Appeal Decision

Appeal Ref: APP/R5510/W/22/3296173

16 Swanage Waye, Hayes UB4 0NX

- The appeal is made under section 78 of the Town and Country Planning Act 1990 against a refusal to grant planning permission.
 - The appeal is made by Mr Sohail Khan against the decision of London Borough of Hillingdon.
 - The application Ref 27066/APP/2020/3930, dated 28 November 2020, was refused by notice dated 24 February 2022.
 - The development proposed is part two storey, part single storey side/rear extension, a hip to gable conversion, a rear dormer extension and 3 x front roof lights, a single storey front extension and front canopies and conversion of the dwelling into two x two-bedroom flats, including the installation of a new vehicle crossover.
-

PROPOSED SCHEDULE OF AREAS
GROUND FLOOR(Flat A)

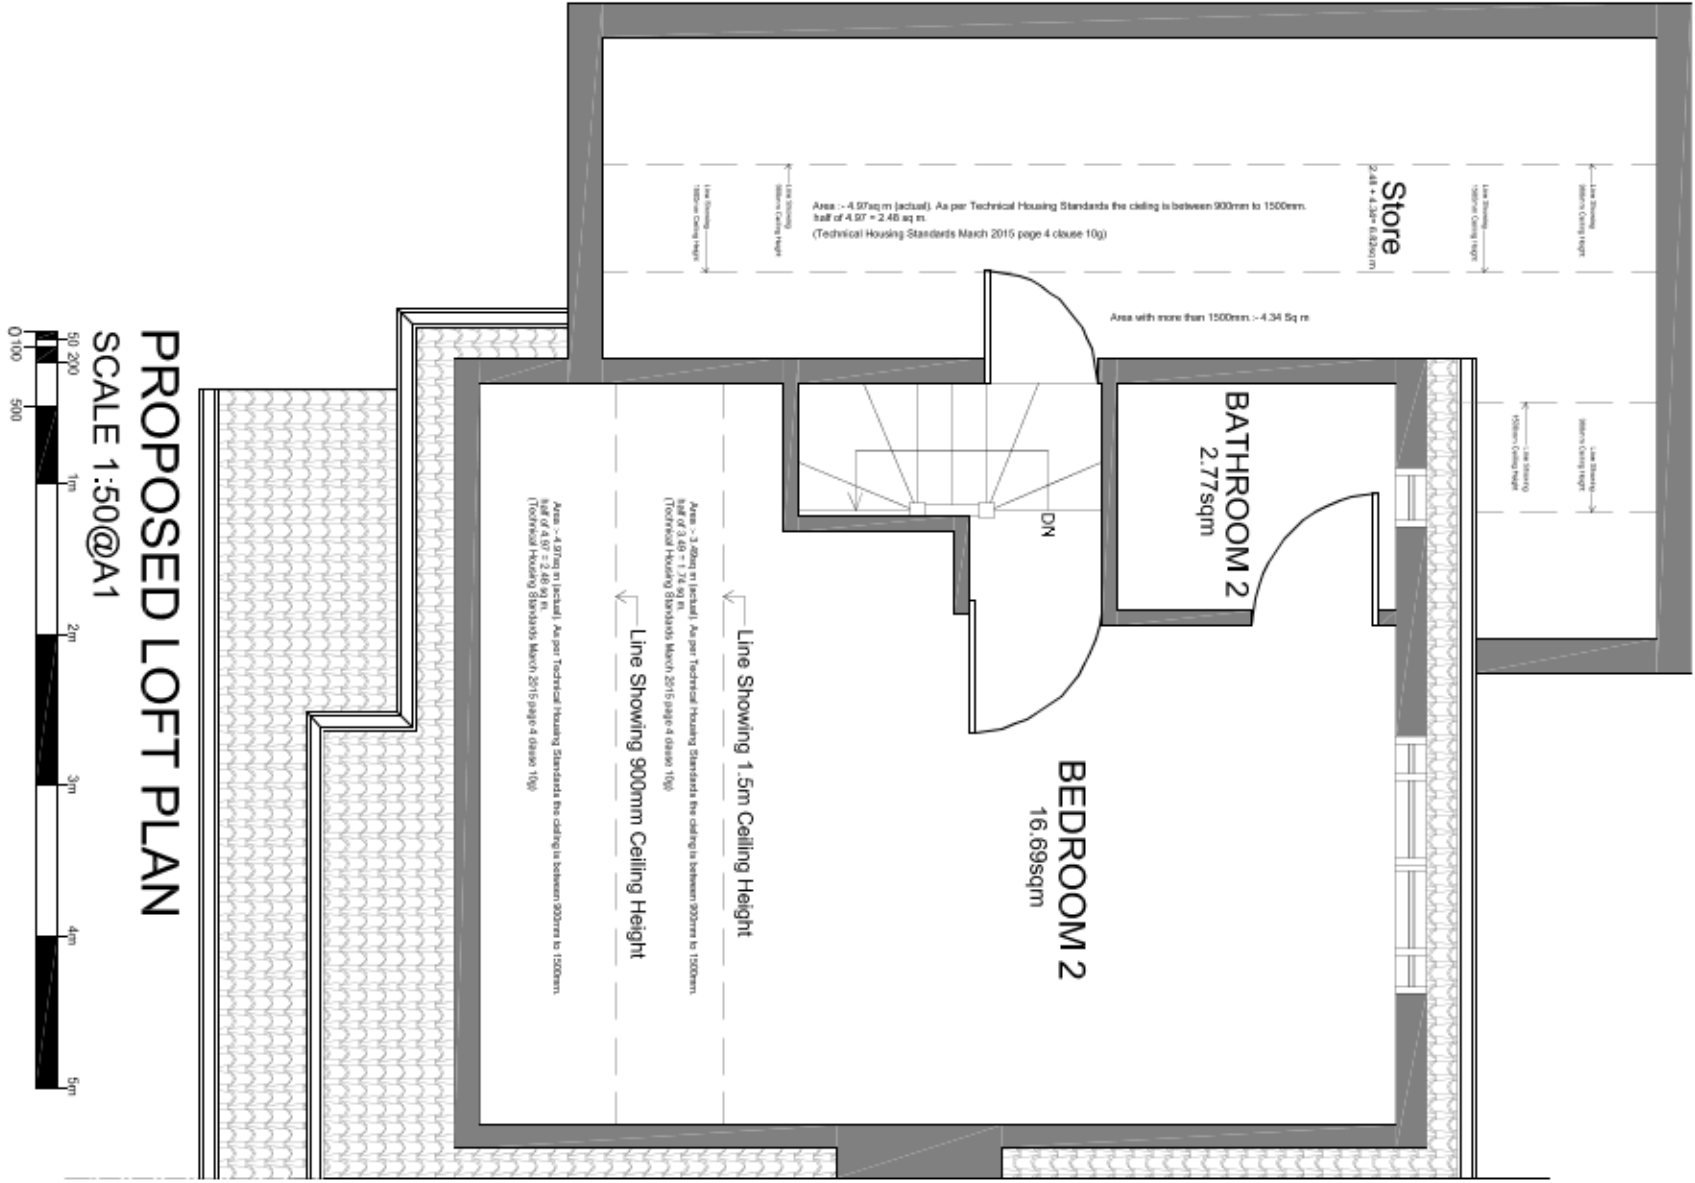
13. There is no indication of whether the rear garden area would be communal space for both flats to use. If this area was to be used by occupants of the upper floor flat then this would have adverse effects on the living conditions of

the occupants of bedroom 2 of the ground floor flat in terms of privacy, as the window to this bedroom directly overlooks the rear garden area.

14. There is no indication that the rear garden area is to be divided between the proposed flats and if this area is not to be a communal space then this would result in one of the flats having little outdoor private amenity space. Whilst the rooms of the proposed flats are acceptable in terms of sizes, the requirement for outdoor space is important for the enjoyment of a property. The lack of outdoor space for one of the flats would result in an oppressive environment that would compromise the living standards of its occupiers.

CAR PARK for First Floor Flat

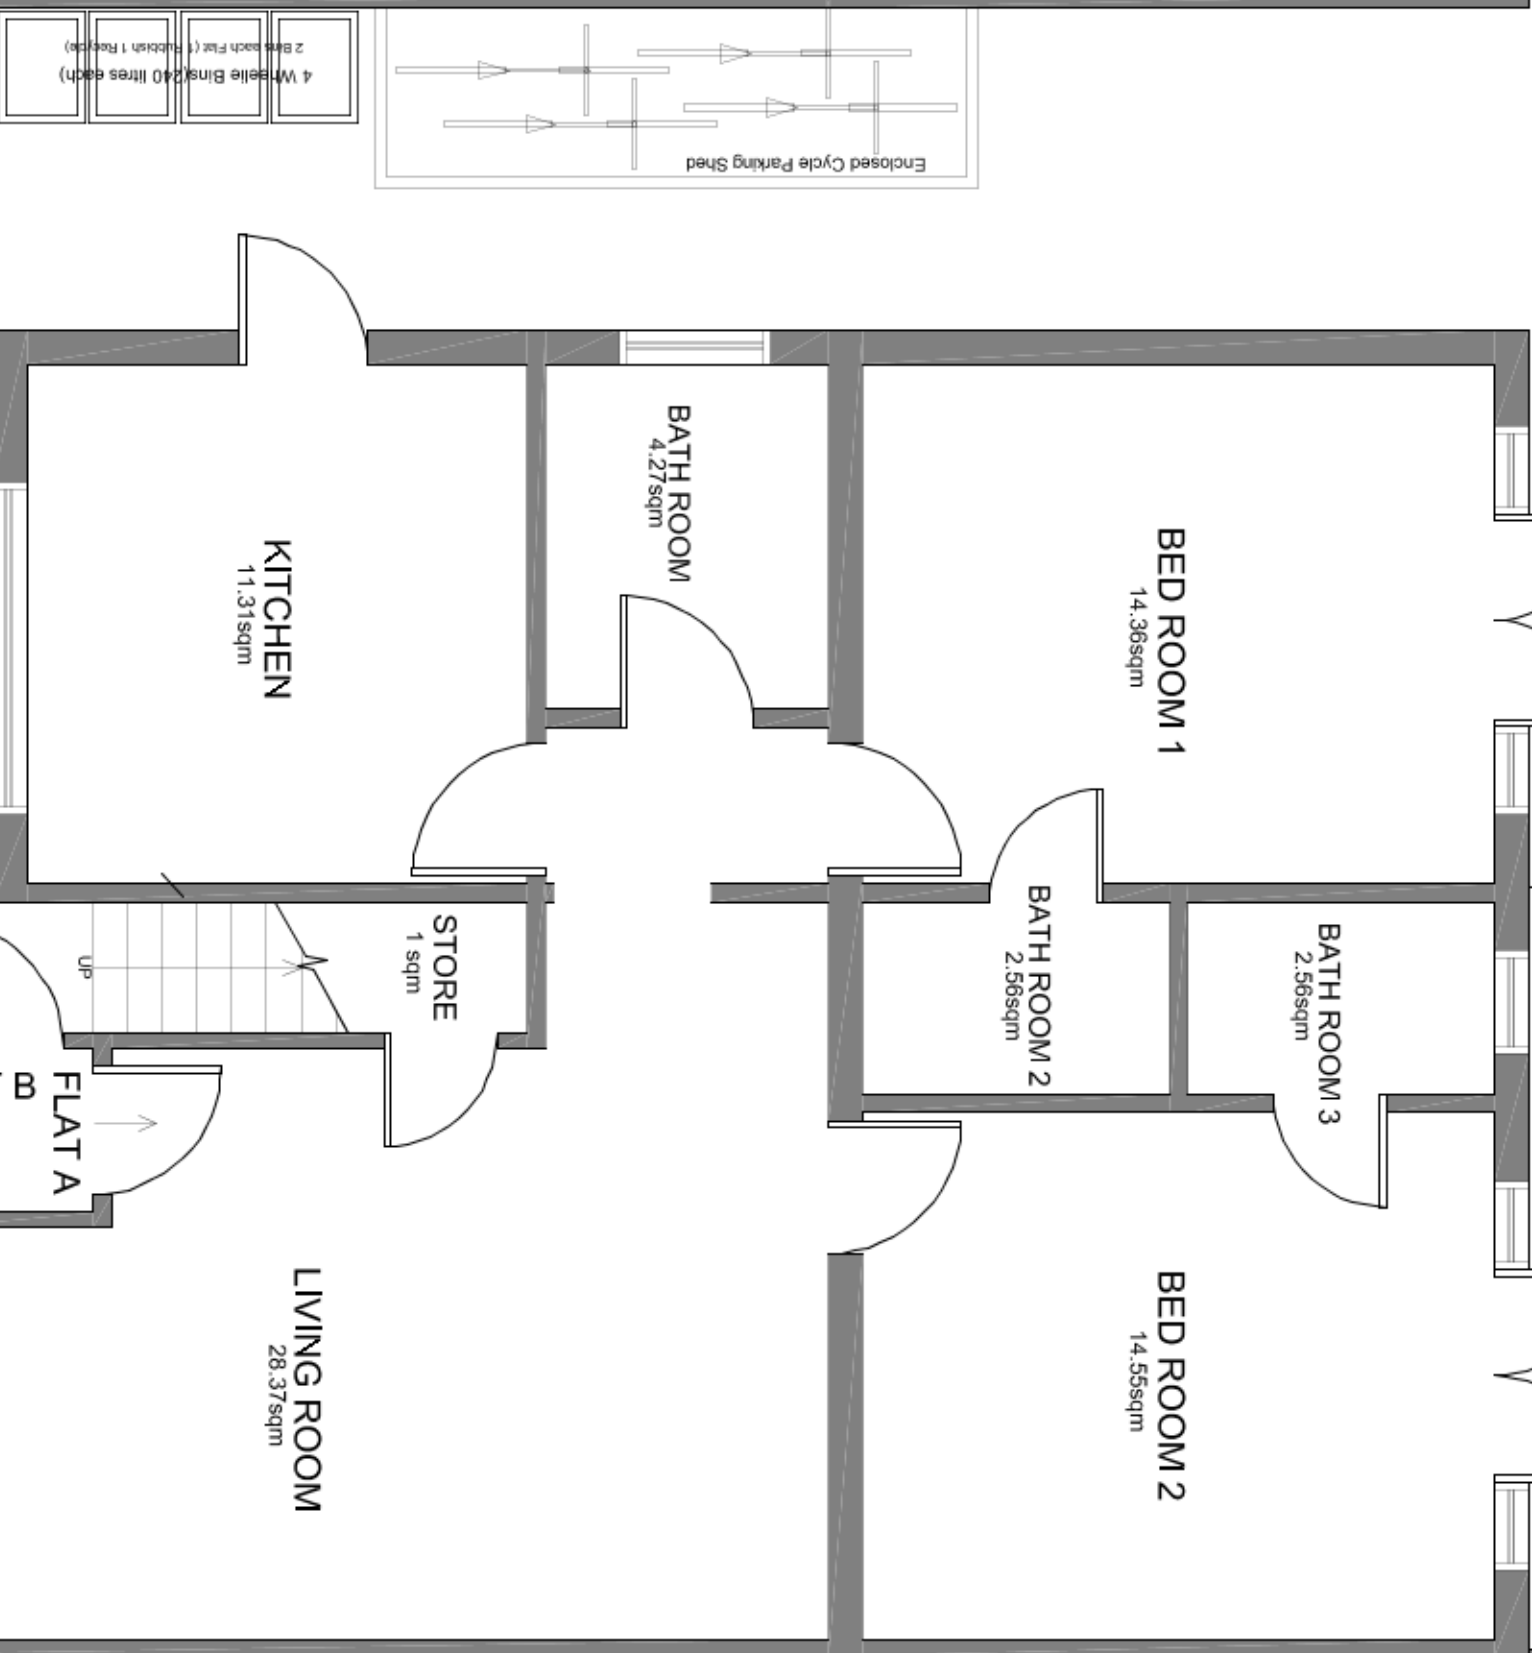
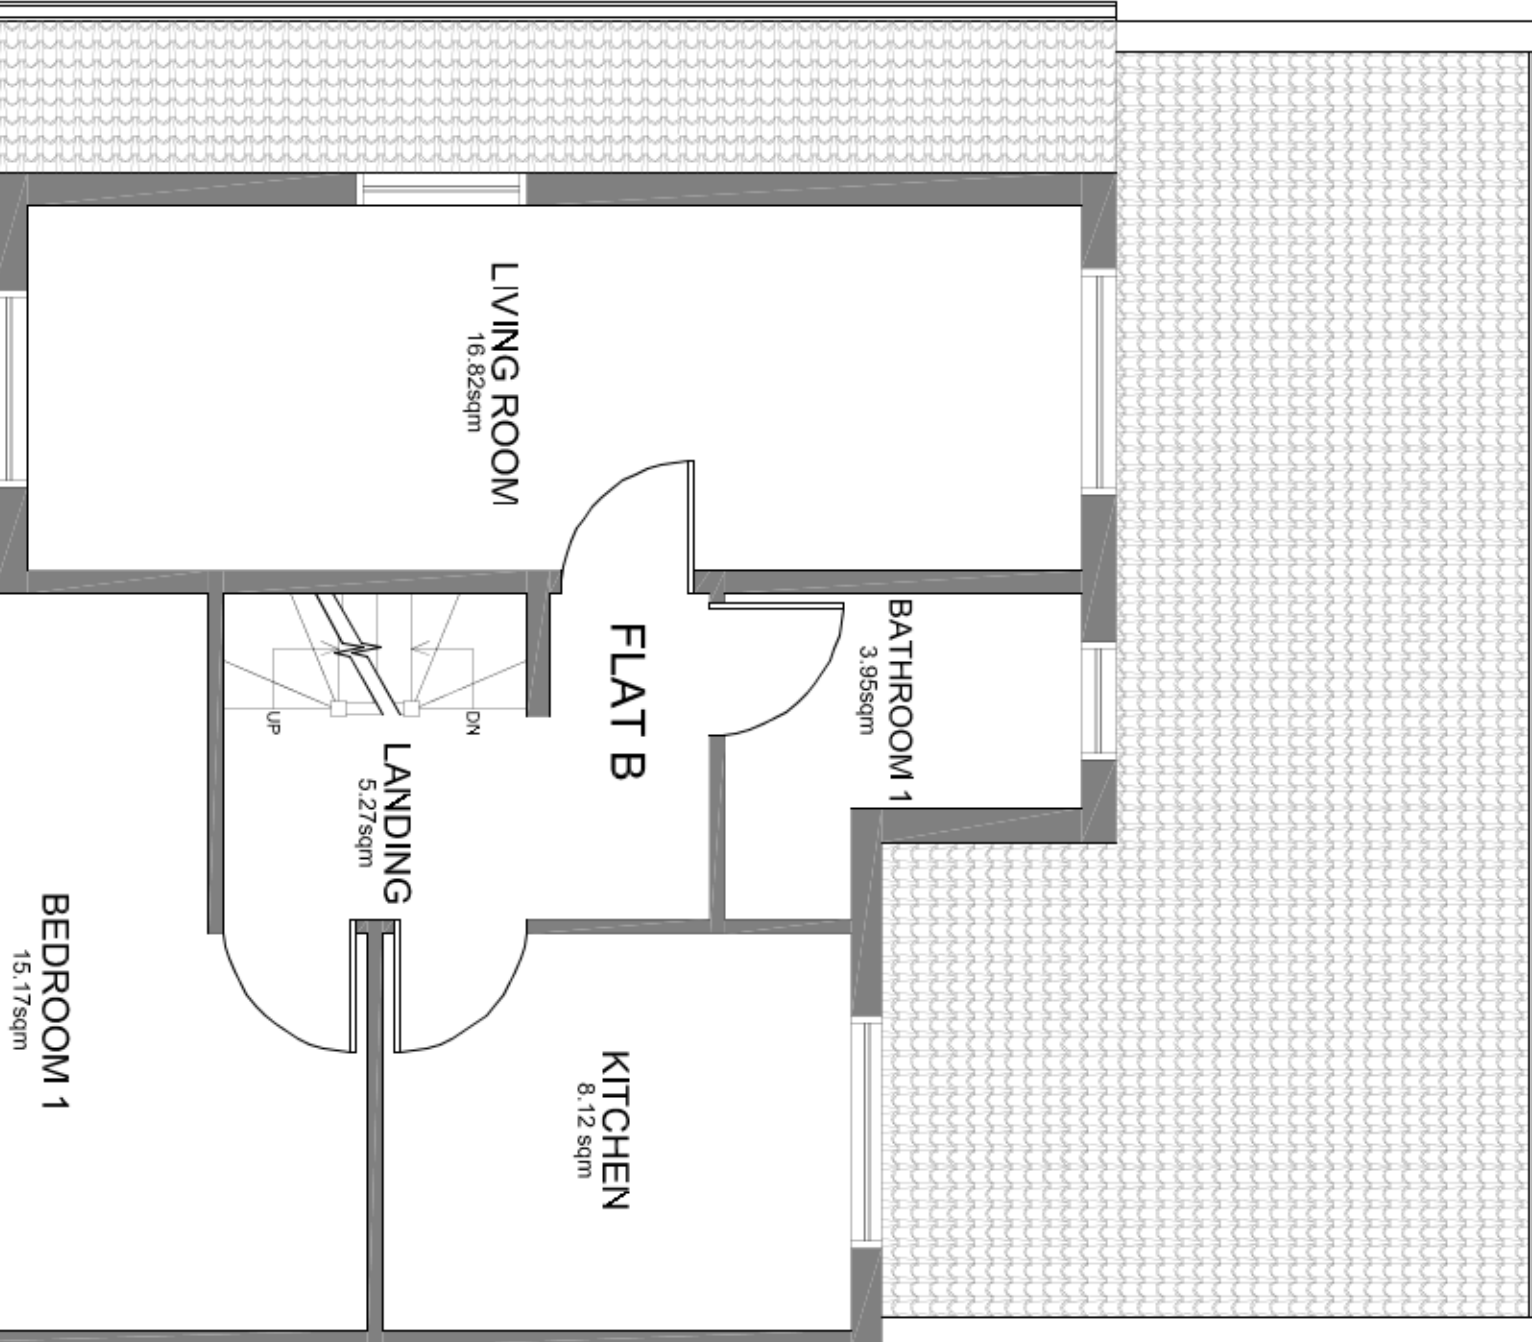
11. Whilst the window arrangements do not alter significantly, the proposal would introduce car parking immediately adjacent to the living room and bedroom 1 of the ground floor flat. Vehicles parked directly adjacent these windows would restrict views and compromise outlook for occupiers of the ground floor flat.

12. The car parking space immediately adjacent the ground floor flat living room is noted as parking for the upper floor flat. The close proximity of this space to the living room window would result in occupants and visitors of the upper floor flat having direct views into the living room window of the ground floor flat which would compromise privacy of the occupants of this room. General coming and goings of vehicles to the upper floor flat car park would also create noise and disturbance to the occupants of the living room.
